Whalley Parish Council Planning Committee
Thursday 18 June 2020
Draft Minutes

Planning App No	Proposal	Plan Officer	Location	Link
3/2020/0385	Single Storey Extension to rear, removal and reinstatement of air	S Kilmartin	Romeros Pizza and Kebabs 37 King Street BB9SP	The Parish Council would wish to point out a discrepancy between the 'Plan' and the 'Application'. The Plan refers to 'welsh blue slates on a min 25 degree pitch' whilst the Application, point 7

PROPOSED REAR ELEVATION.

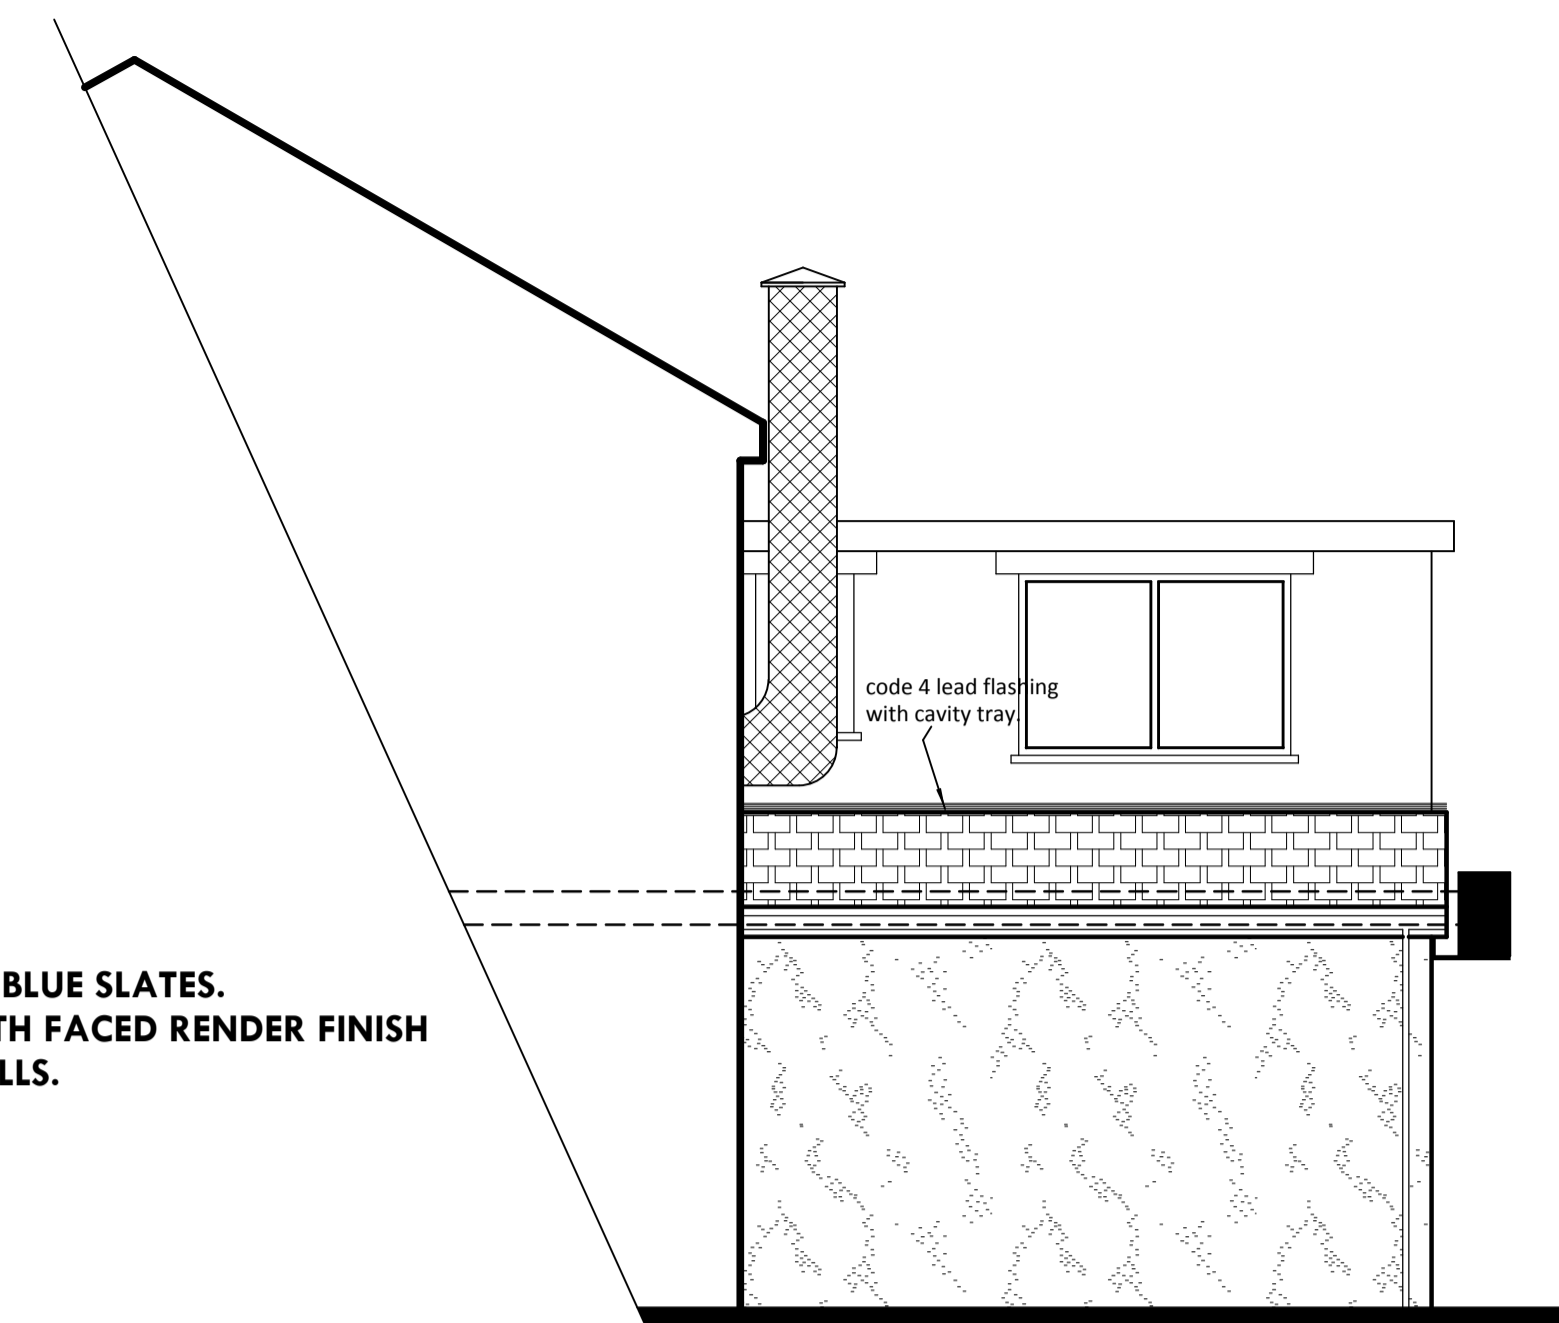
conditioning unit to rear elevation			indicates 'Marley grey conc roof tiles'. Considering Romeros Pizza is in a conservation area the former choice would seem the more appropriate.
--	-------------------------------------	--	--	---
